**From:** [Mark Weston](#)  
**To:** [A303 Sparkford to Ilchester](#)  
**Subject:** Response to letter sent 5th. November, reference TR010036-001538  
**Date:** 25 November 2019 18:42:49

I am sending these representations on behalf of the British Horse Society.

The Society is concerned about the provision of routes for equestrians in mitigating the severance of routes caused by the dualling of the A303 between Sparkford and Ilchester. As well as the detail of the opportunities with this project which we have submitted in earlier deadlines, our main concerns are

Drawing Title
**RIGHTS OF WAY AND ACCESS PLANS
REGULATION 5(2)(k) and 5(2)(o)
SHEET 2 OF 4**

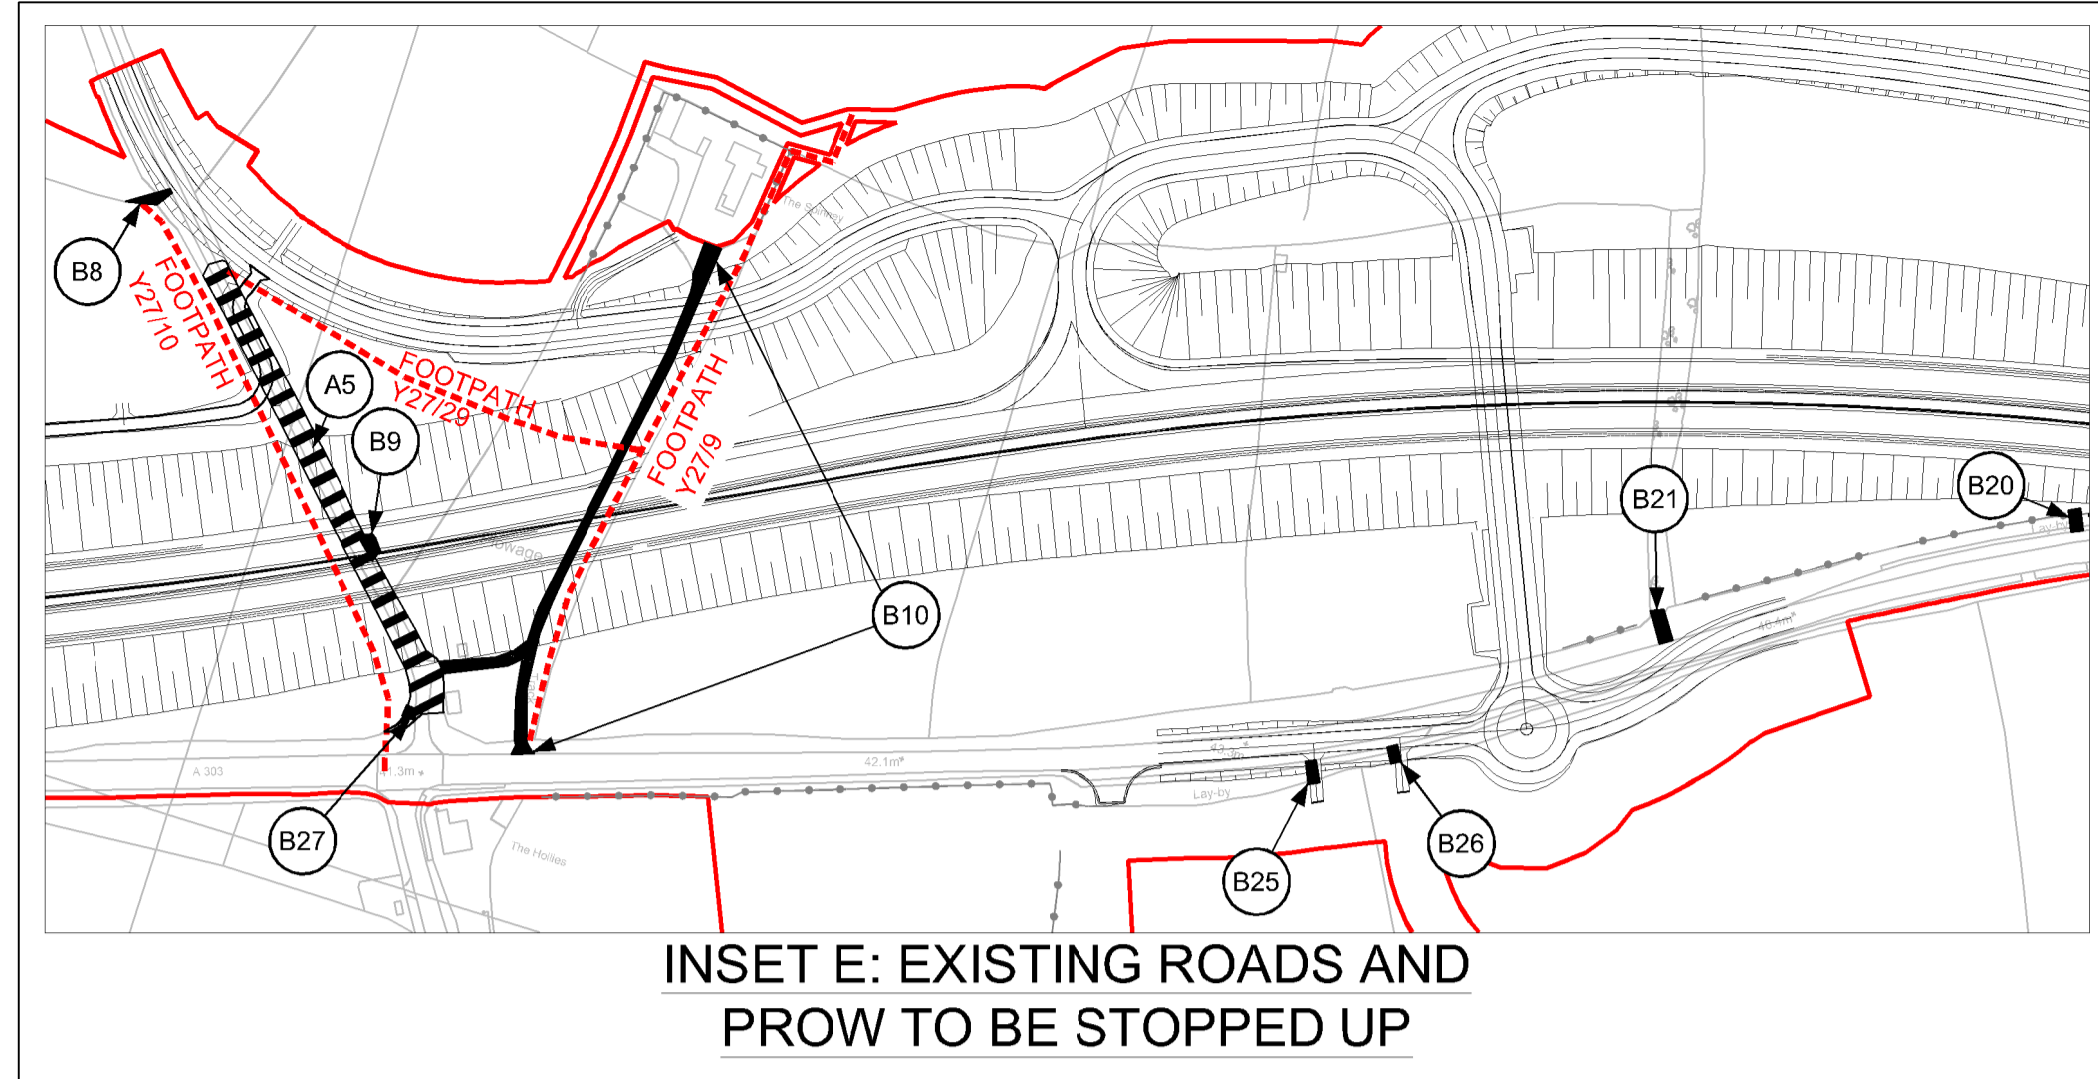
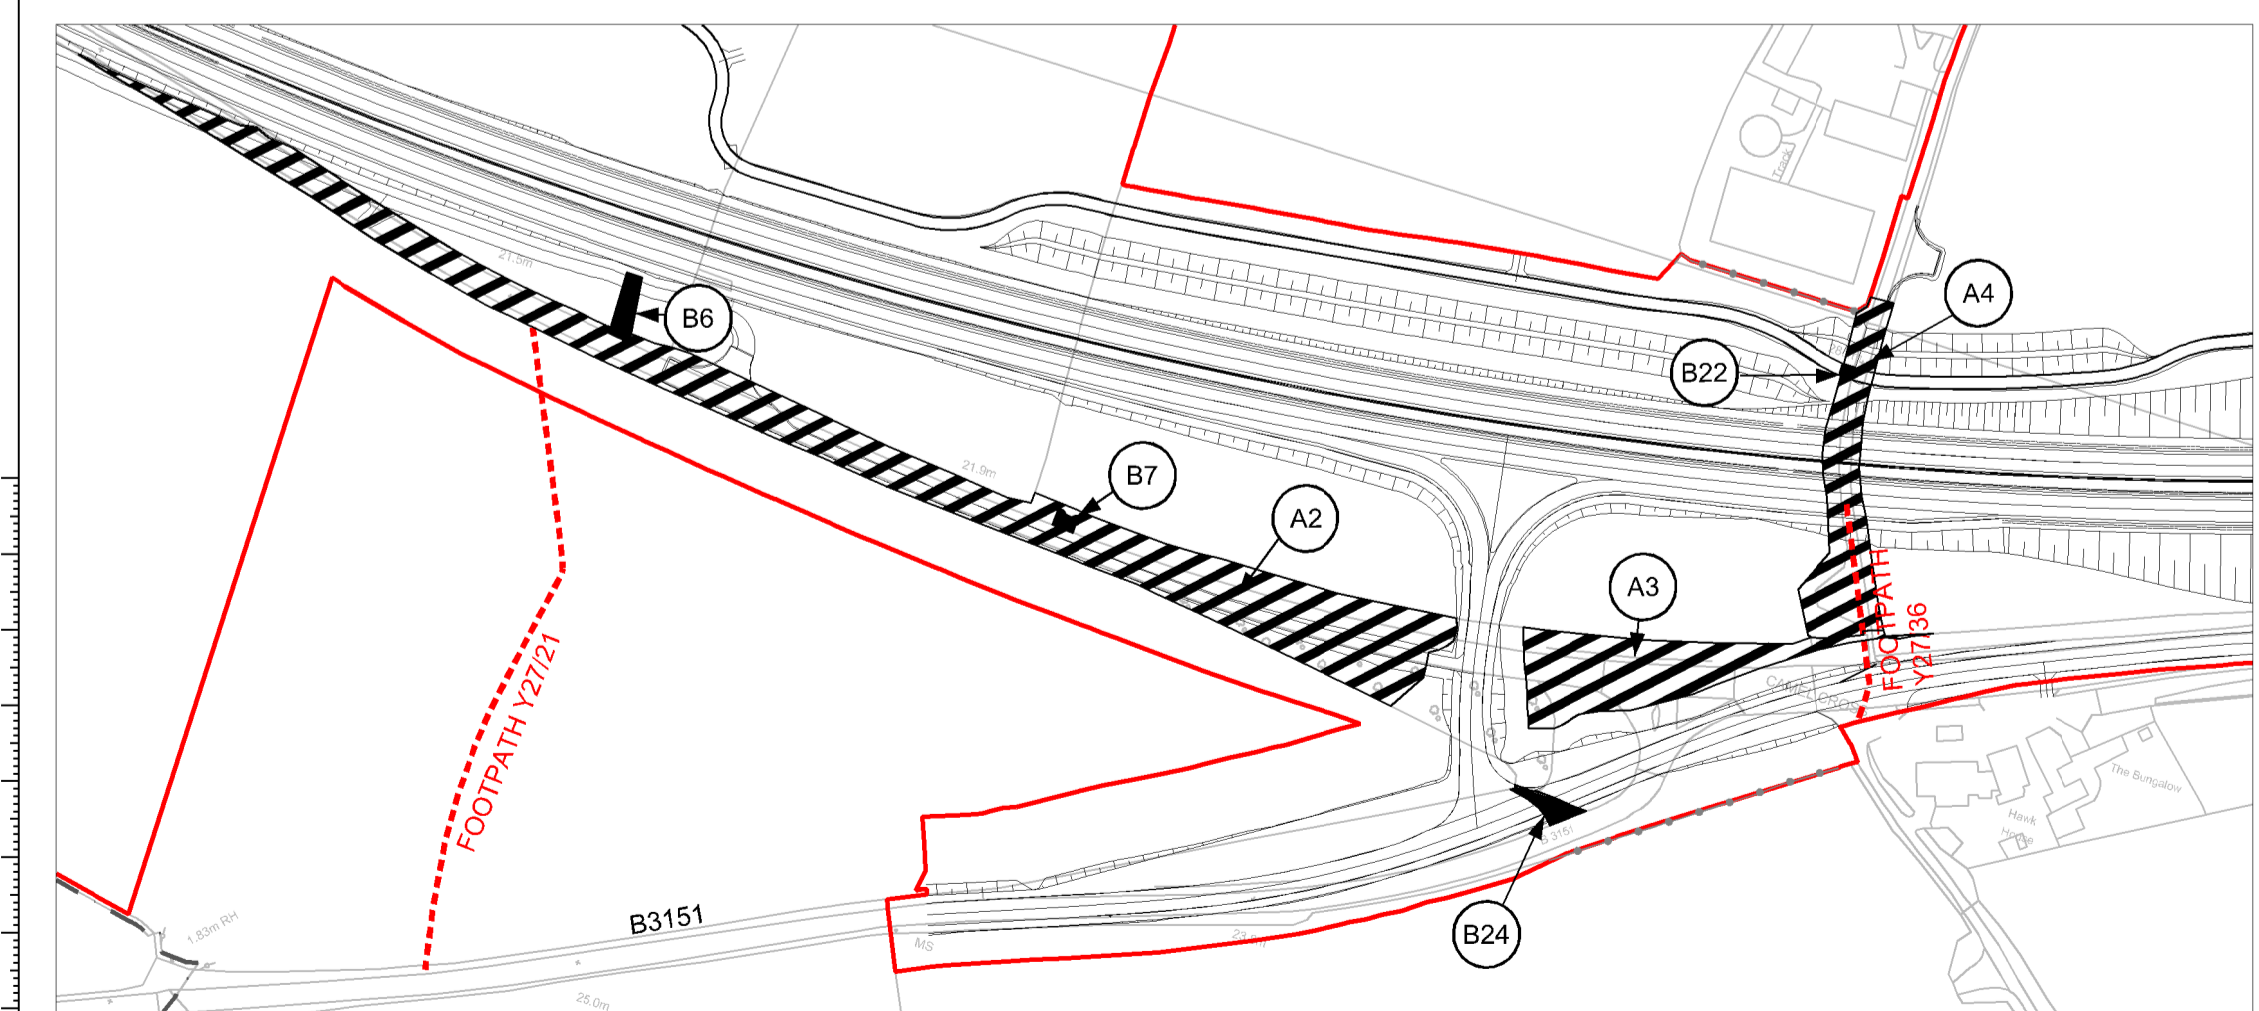
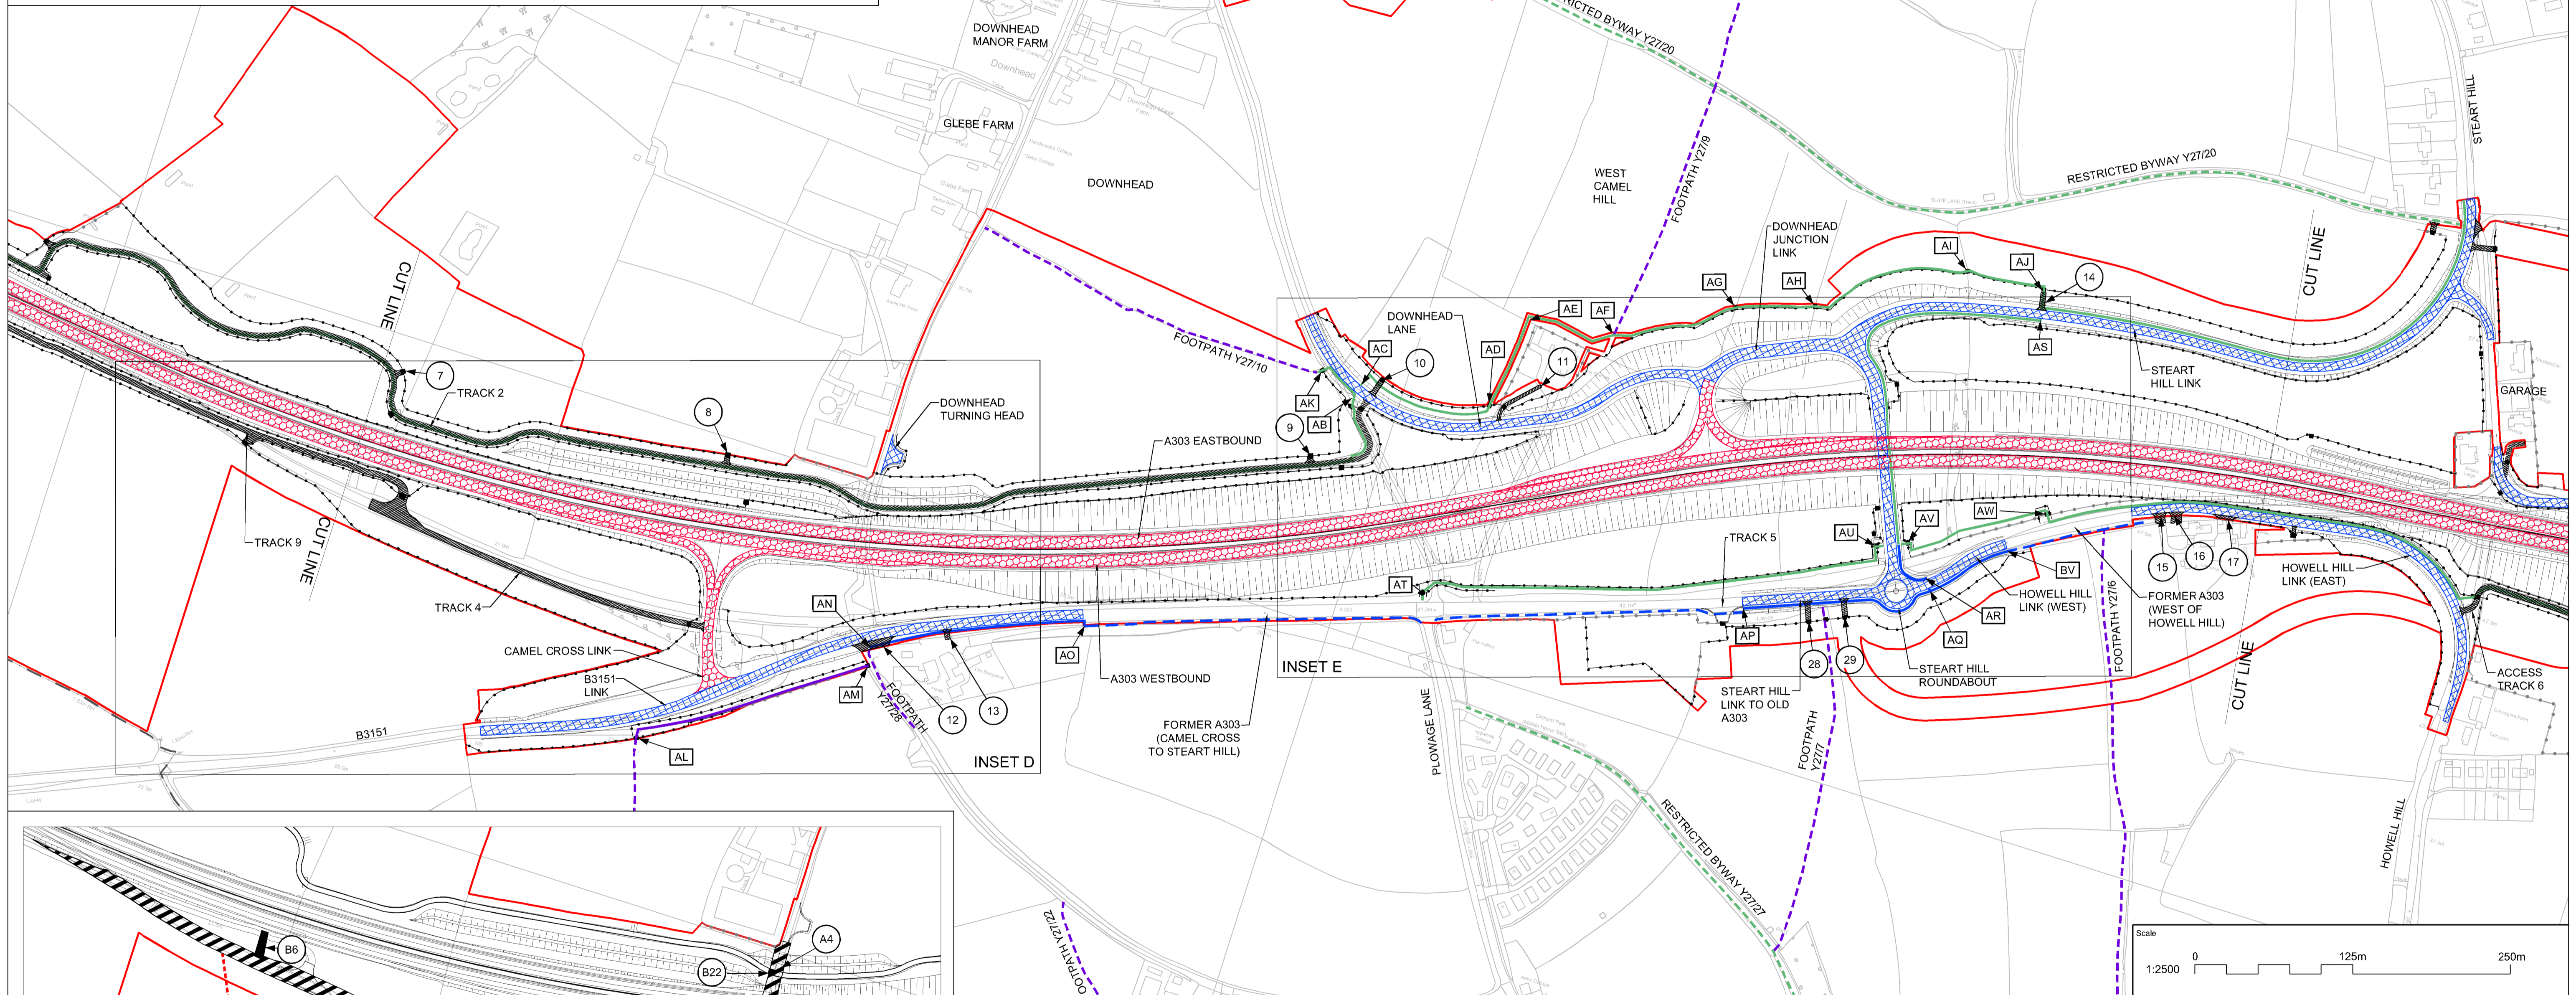
Another concern is that by designating footways and cycleways, equestrians are going to be excluded on routes which they can currently use. A particular example is the verge around the southern section of the Hazlegrove roundabout. Currently equestrians can use this wide section of grass in both directions. By making it a footway and cycleway, equestrians will be forced onto the vehicular carriageway, and have to ride or drive around the roundabout and across the off ramps. If the verge was dedicated as a restricted byway, and it is certainly wide enough,

equestrians could travel in both directions, off the carriageways carrying motorised traffic. **The British Horse Society would be interested to know what risk assessment has assessed that it would be safe to leave equestrians on the carriageway in these locations when a decision has been taken that it would not be safe to leave walkers and cyclists on the carriageway.**
